**Orange Private Hospital Modification 4 (MP08_0233 Mod 4)
Request for Additional Information**

DRAWING
PLANTING PLAN - NW

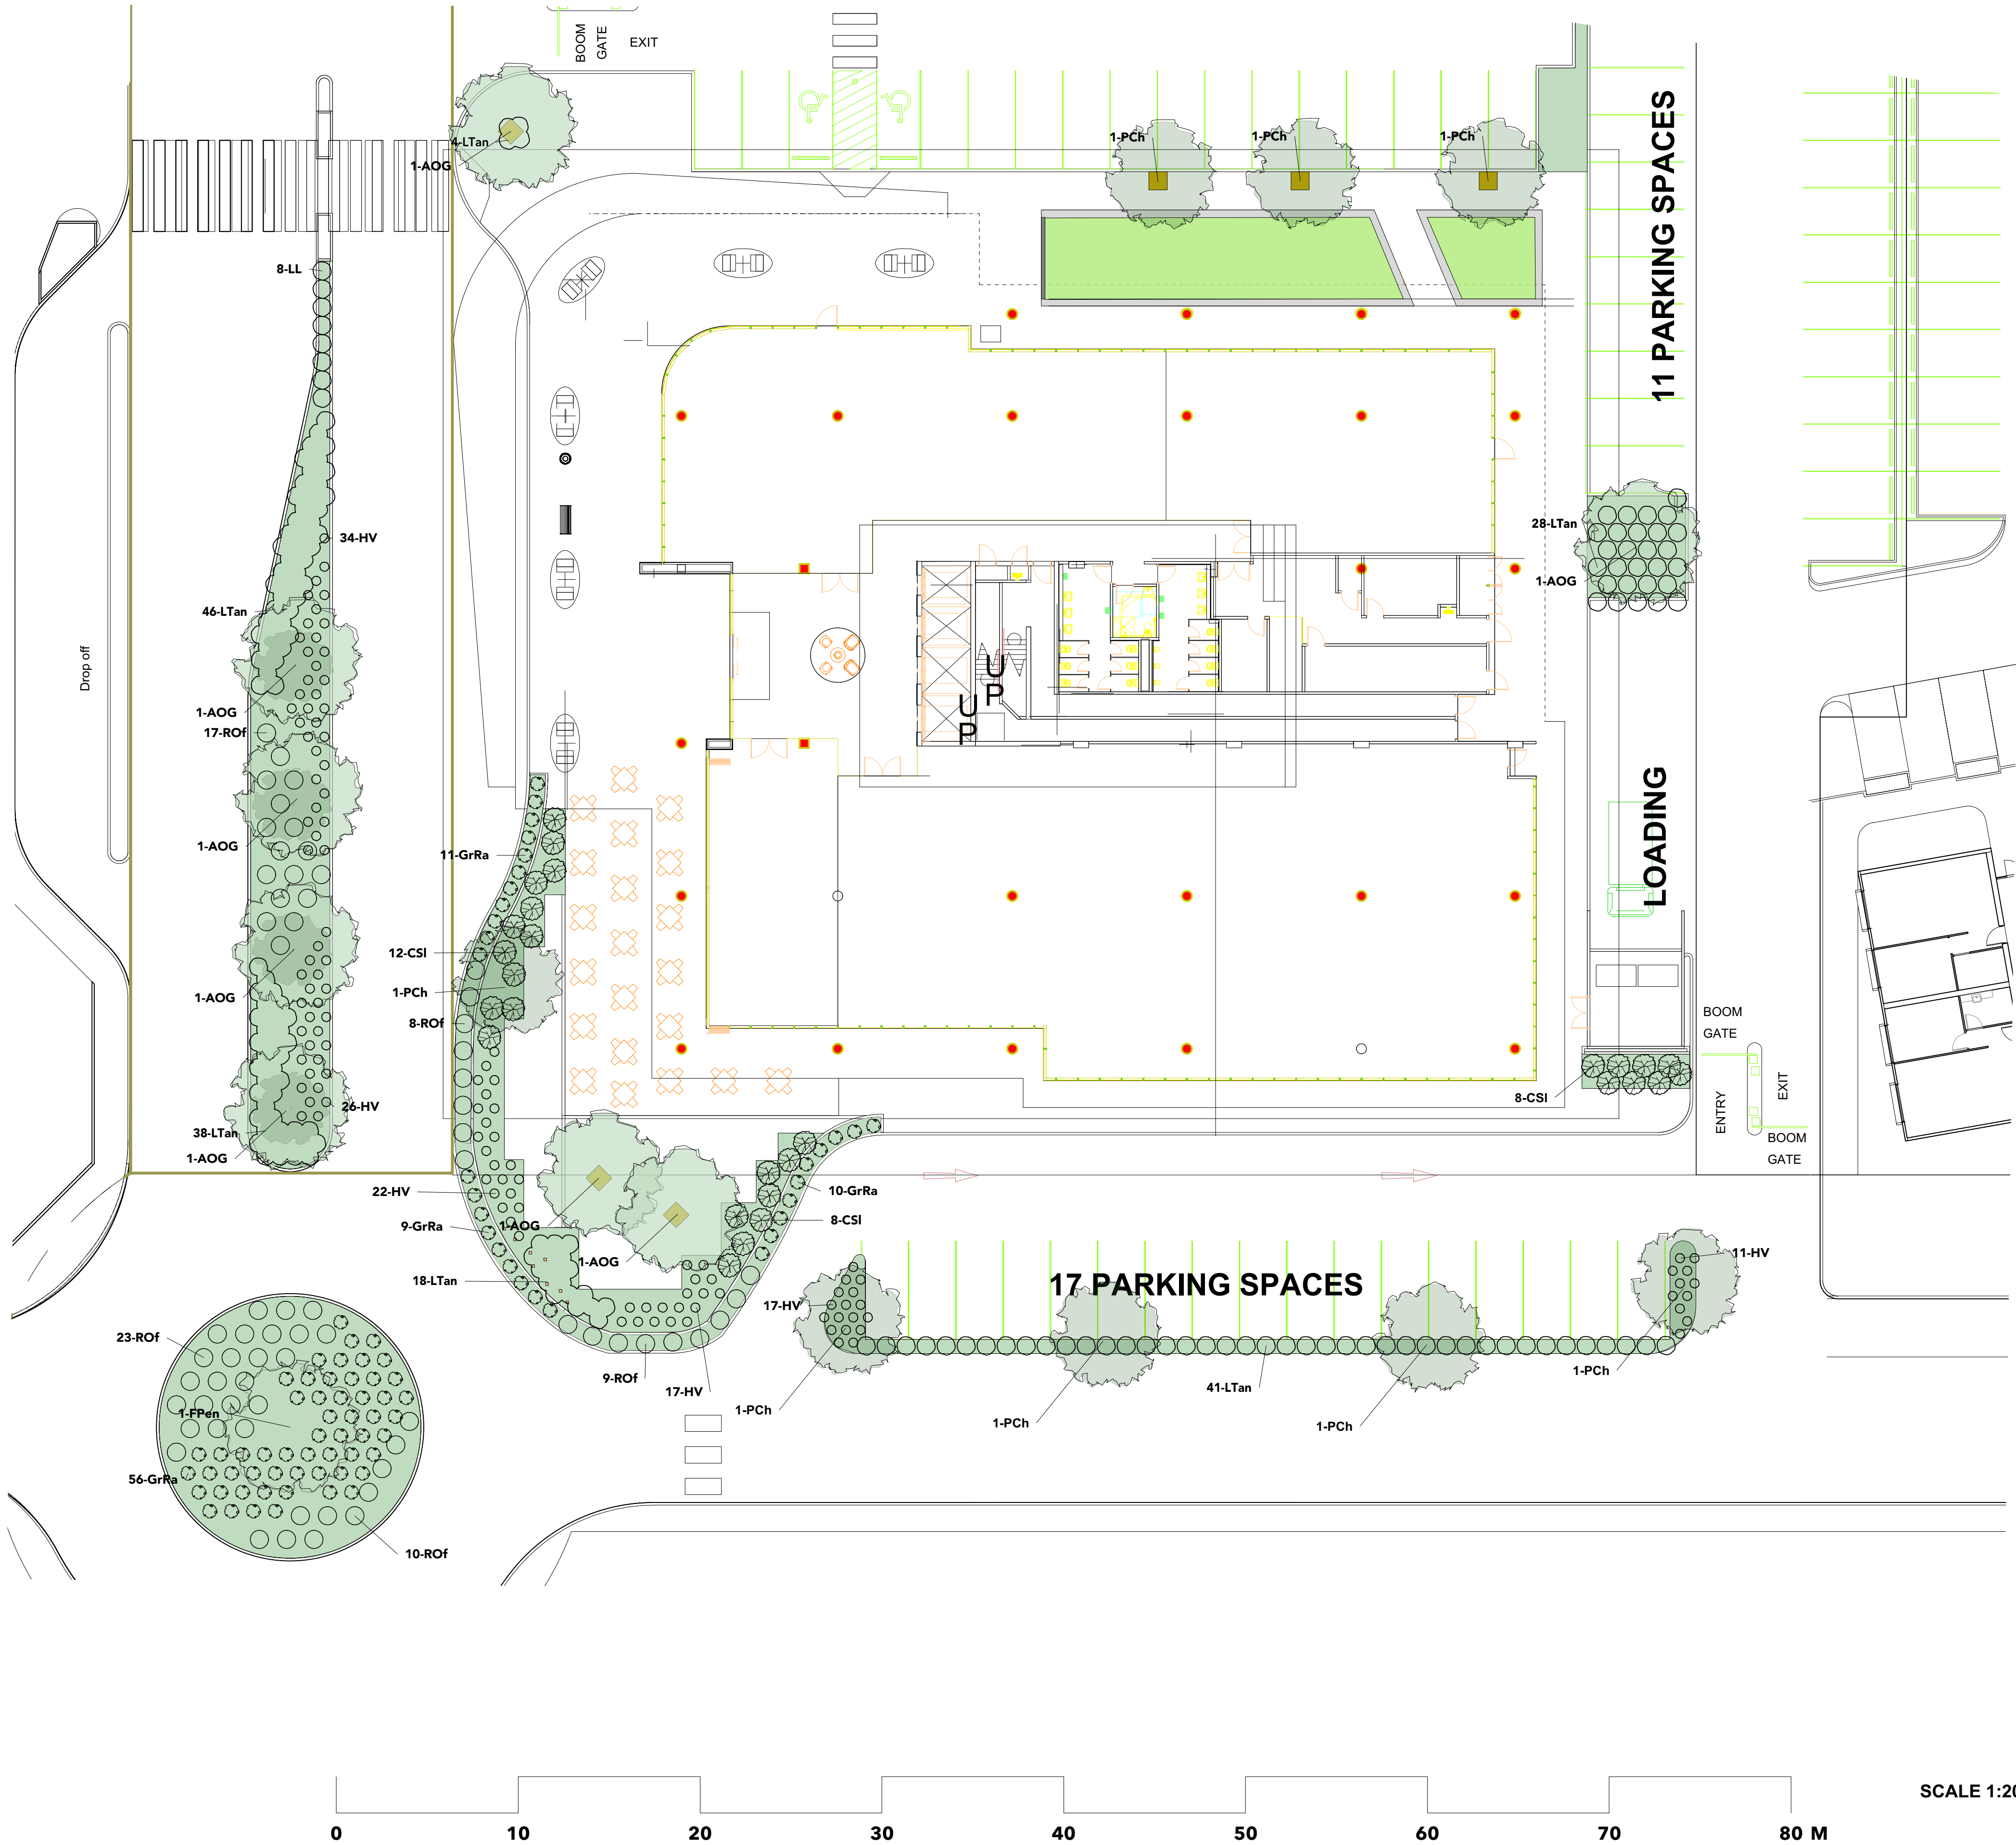
- reasoning for the loss of trees onsite as a result of the site reconfigurations. Landscape plans are to be submitted demonstrating changes to tree planting from previously approved plans.
- justification for the roof top enclosed space and why this should not be considered gross floor area (GFA). If the enclosed space is considered GFA, appropriate action should be undertaken regarding the concept plan GFA total. In addition, further details of the rooftop garden proposed should be provided.
- as the submitted location plan Drawing Number SK02, Rev H dated February 2017 appears to have a drafting error which shows an area of landscaping covering the southeast corner of the reconfigured Medi-Motel, an updated plan is to be submitted.
